NSIP Reference Name / Code: Meridian Solar Farm
Interested Party reference: TBC

Title: Natural England's Deadline 2 Response to the Applicant's Deadline 1 Updates

Annex 1 – Natural England’s Updated Advice at Deadline 2

Figure 3: Proposed Auger Locations within Inaccessible Areas for Area 1 (Highlighted in Red (inaccessible areas) and Grey (not surveyed))

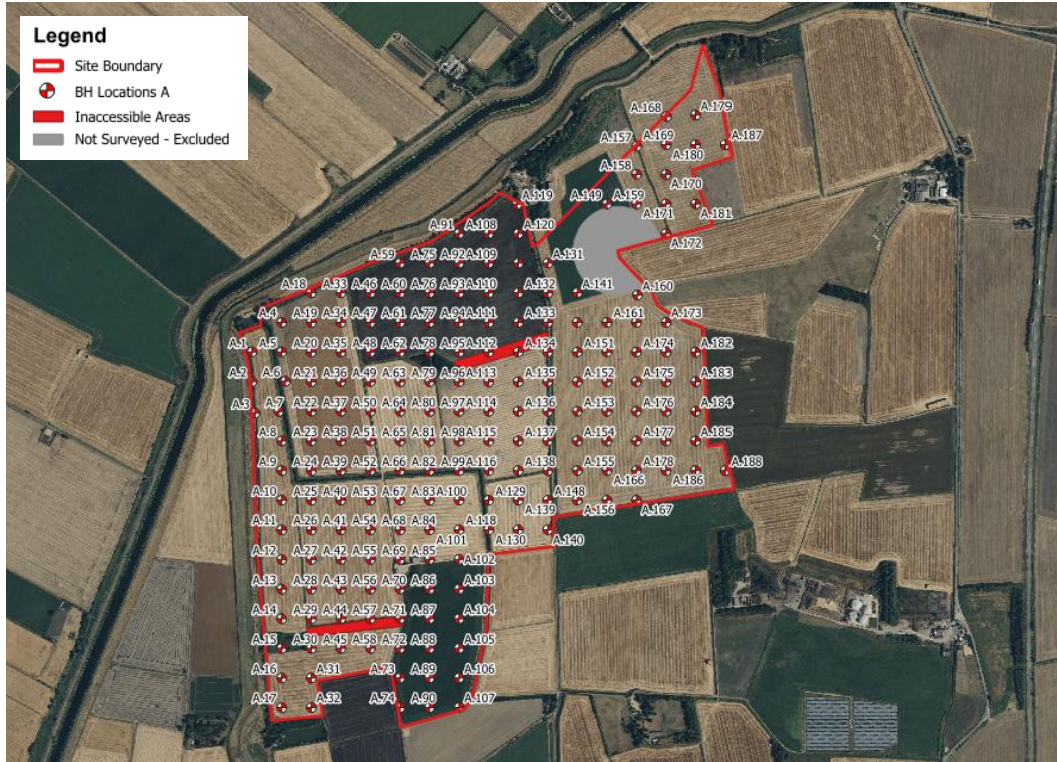
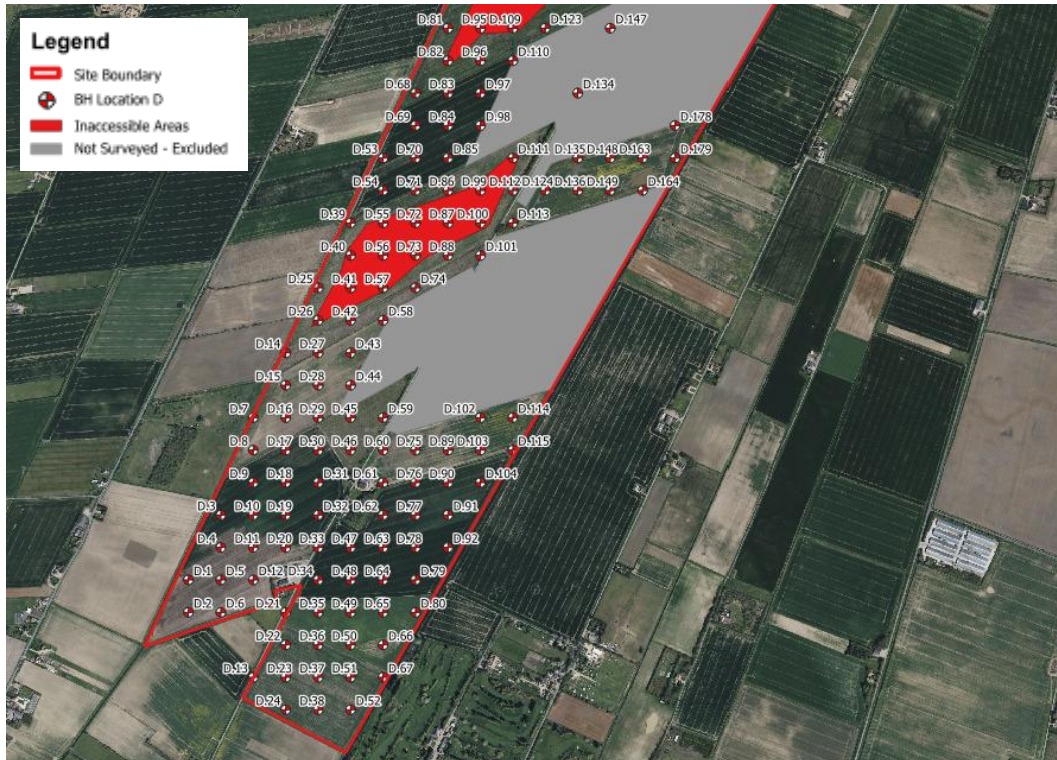
In general, where there are legitimate constraints preventing survey access, the use of predictive mapping or professional interpretation to inform the assessment is considered appropriate, provided that the outstanding survey work is secured and completed post-consent to verify land quality and inform any necessary management measures.	
BMV5.1 - ALC Survey Findings – Mapping	NE does not advocate mapping every isolated auger observation as a discrete polygon. However, neither does NE consider field-average mapping to be an appropriate basis for determining the spatial extent of BMV land. ALC mapping should instead be derived from professional interpretation of the survey evidence, ensuring that coherent areas of higher quality agricultural land are identified and represented where they can reasonably be expected to occur. NE does not consider that the evidence presented demonstrates that field boundaries consistently coincide with changes in soil type or ALC grade across the Site. Agricultural field boundaries are management features and do not necessarily reflect changes in soil properties, wetness, droughtiness or land quality. The use of field boundaries as grade boundaries therefore risks introducing artificial mapping units that do not accurately represent the distribution of agricultural land quality. This concern is reinforced by the Applicant's own findings which identify local variability in topsoil depth, wetness limitations and ALC grade sufficient to produce materially different outcomes between the field-average and auger-by-auger analyses (paras 5.6.15-5.6.17). NE considers that ALC boundaries should be derived from interpretation of the soil survey evidence, landform, drainage characteristics and soil-landscape relationships, rather than being aligned to field boundaries unless there is clear evidence that the field boundary coincides with a genuine change in agricultural land quality. Accordingly, NE remains concerned that the mapped extent and distribution of BMV land may not be fully representative of the survey evidence presented.	Amber

Figure Auger Sample locations and ALC Grades		
Job Meridian Solar Farm		
Client AECOM		
Figure No. 5	Revision	Date 03 December 2025
Drawn by SS	Checked by EH	Scale 1:17,000
Job No. 250635

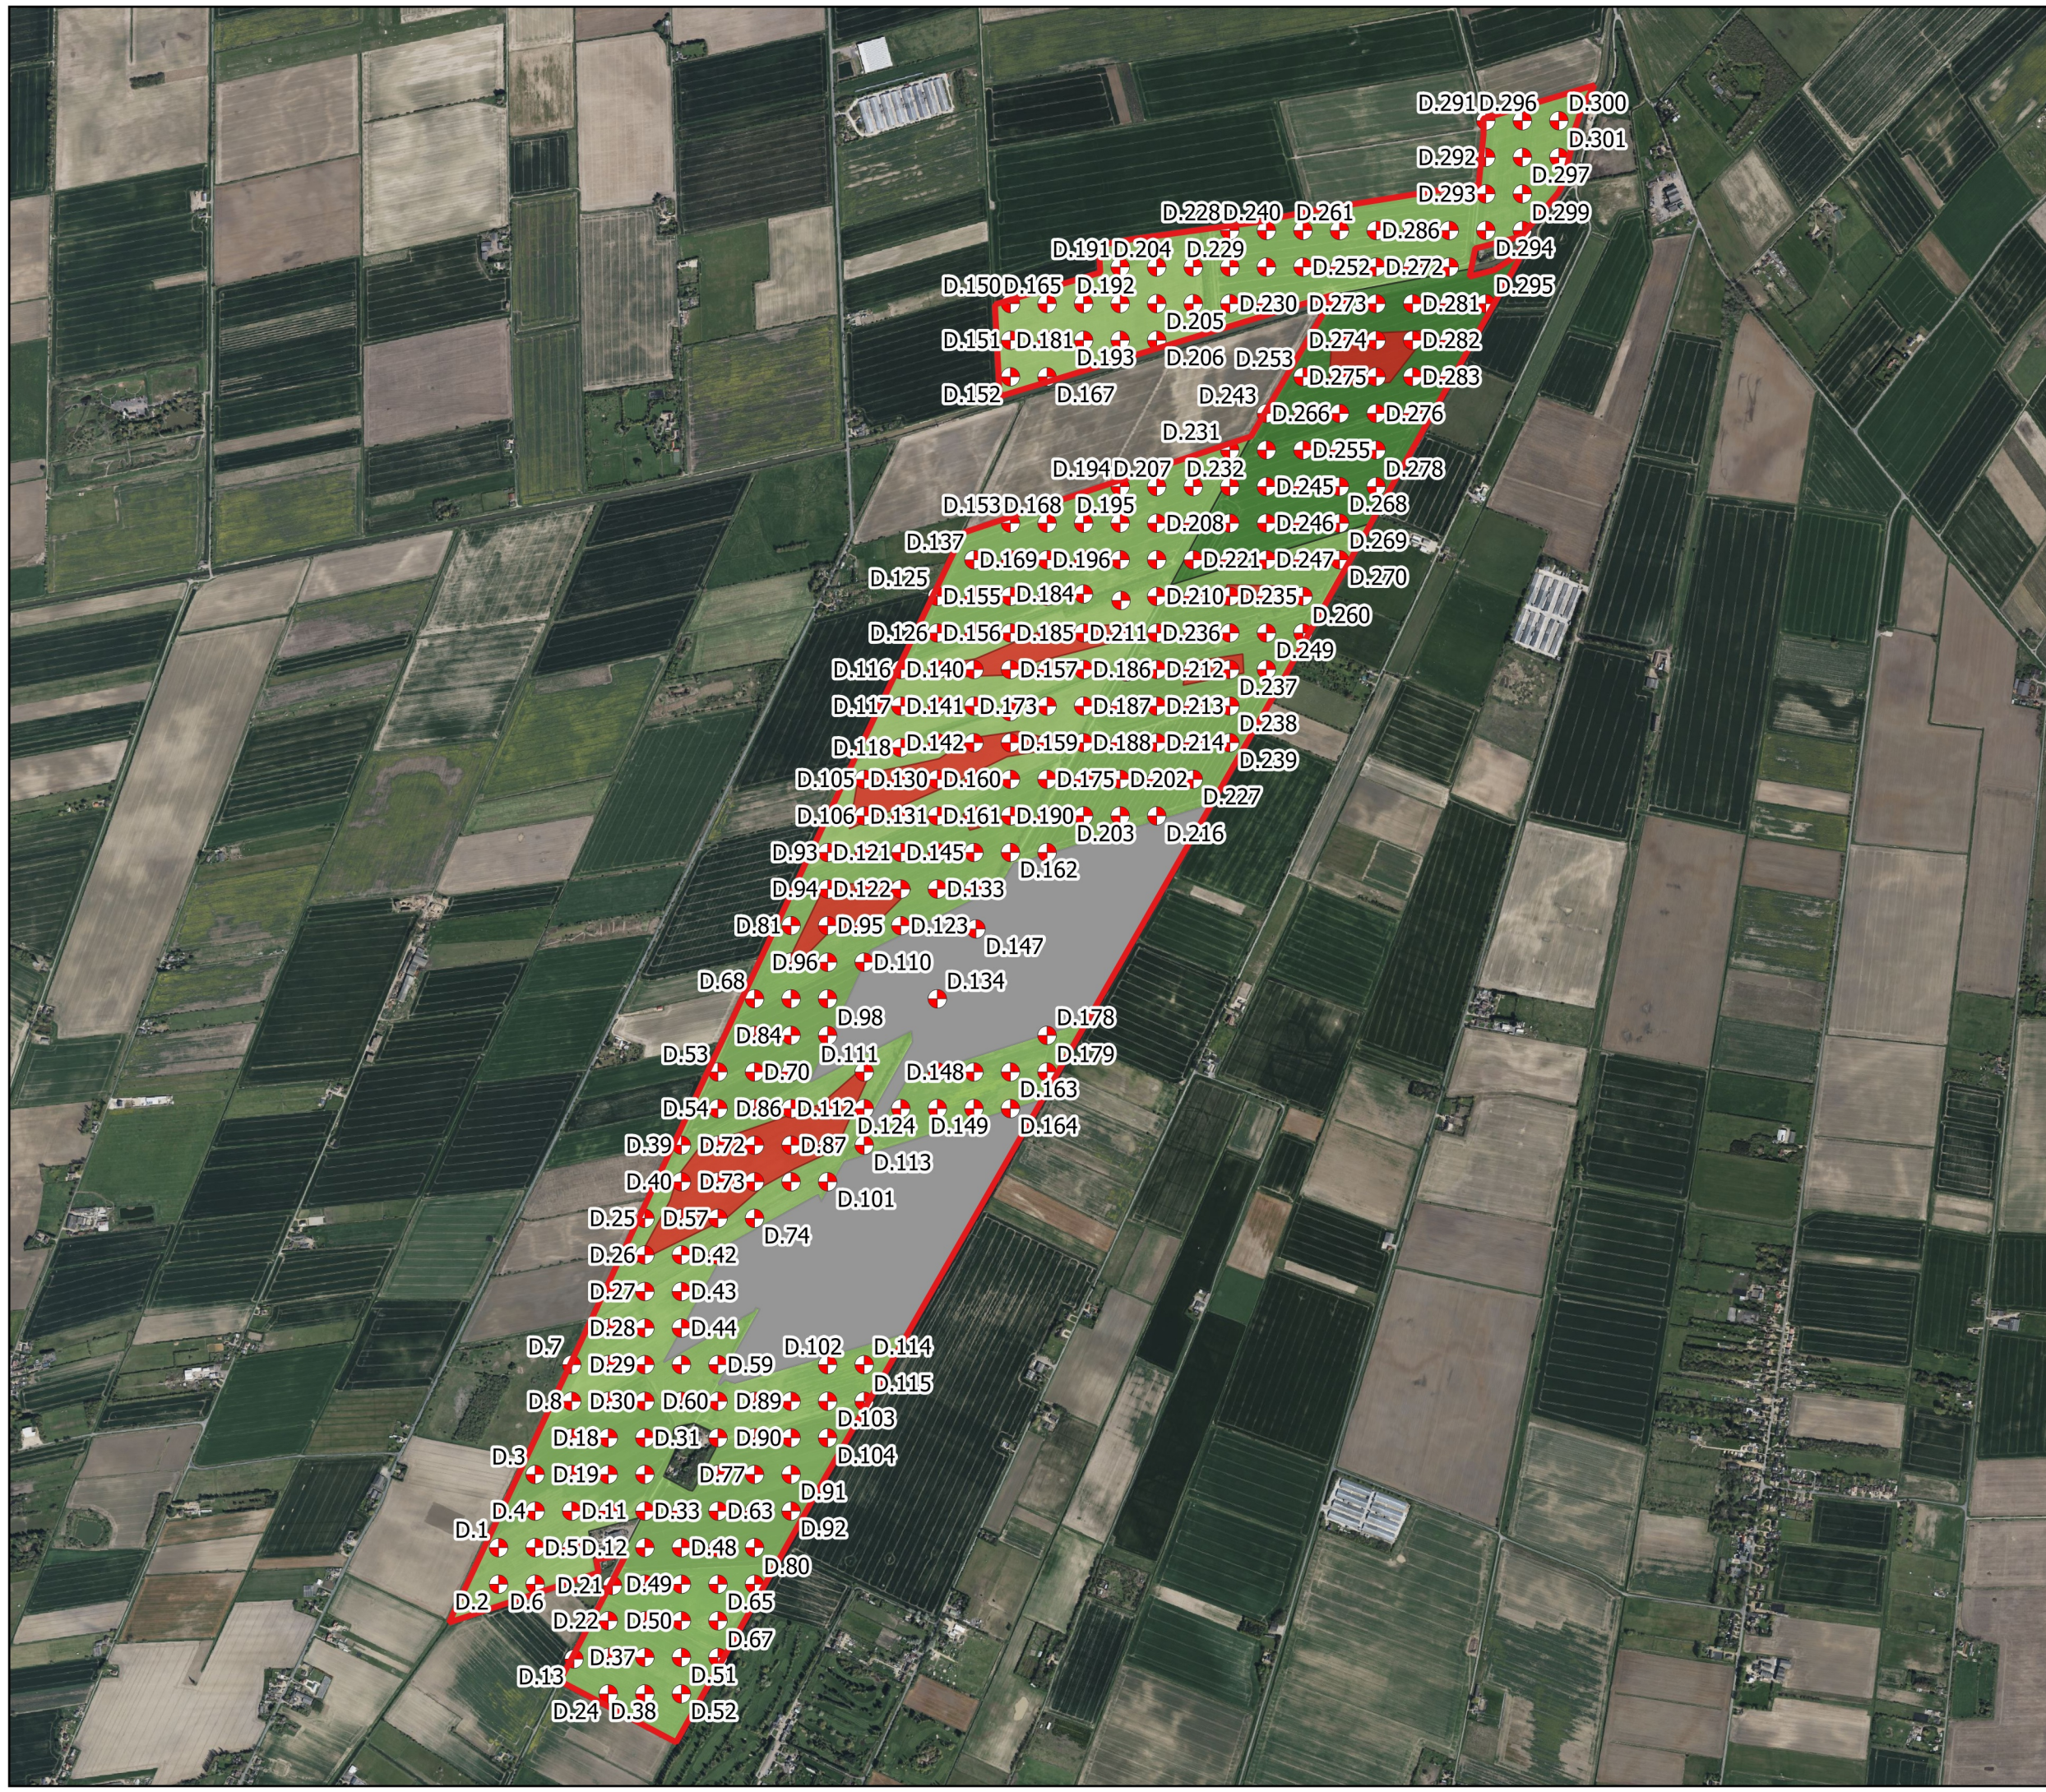
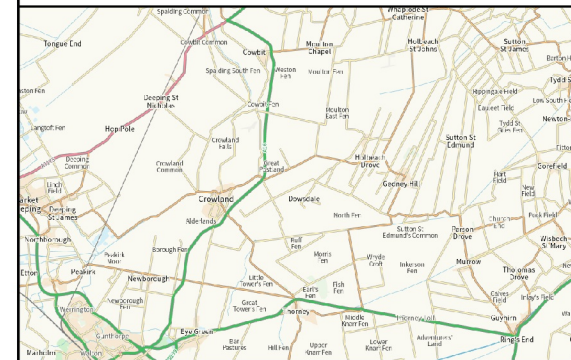
BMV7 - ALC Survey Findings – Soil Auger Records	NE welcomes the provision of additional pit descriptions, auger logs and photographs. However, concerns remain regarding the consistency between the evidence presented and the conclusions drawn from that evidence. The auger logs record remarkably similar horizon depths, colours, structures and profile descriptions across extensive areas and separate land parcels. This appears inconsistent with the level of variability described elsewhere in the assessment. In particular, Chapter 5 states that local variation in soil characteristics is sufficient to generate materially different ALC outcomes between the field-average and auger-by-auger analyses, increasing BMV land from 35.2% to 39.2% (paras. 5.6.15-5.6.17). NE also notes an apparent contradiction between the Applicant's position on soil variability. In BMV5.1, local variation is presented as insufficiently meaningful to warrant separate mapping units, whereas elsewhere the Applicant relies upon variation in topsoil depth and profile characteristics to explain differing ALC grades over relatively short distances. The pit photographs and descriptions suggest greater variability in soil horizons than is reflected in many of the auger logs (paras 5.4.9, 5.6.15-5.6.17). NE further notes that the revised reports rely upon archaeological trench exposures to describe soil structure and wetness characteristics. NE accepts that the use of archaeological pits can be appropriate where conventional pit excavation is not practicable. However, the methodology should have been more fully described within the ALC reports and ES Chapter 5. Limited information is provided regarding trench preparation, profile exposure, orientation and confidence in the observations used to determine structure, biopore abundance and slowly permeable layers.	Yellow

Finally, the pit descriptions and logs repeatedly record grey and ochreous mottling within clay subsoils, yet the wetness assessment concludes that gleying is absent within the upper profile. The basis for this interpretation is not clearly explained within the reports & clarification is requested (as per our advice on BMV6). NE does not seek additional survey work in relation to these matters but wishes to draw them to the attention of the Examining Authority when considering the overall robustness of the ALC assessment.	
BMV8 - ALC Survey Findings – Soil Lab Analysis	Natural England notes that the laboratory testing undertaken has provided the information necessary to inform the ALC assessment. Although it differs from the standard testing approach typically used for ALC surveys, no further issue is raised. Natural England considers the matter relating to HCI testing to be clarified & remove our request for a worst-case scenario assessment assuming all soils are calcareous. However, the further information requested within BMV6 regarding soil wetness class is still required.	Green
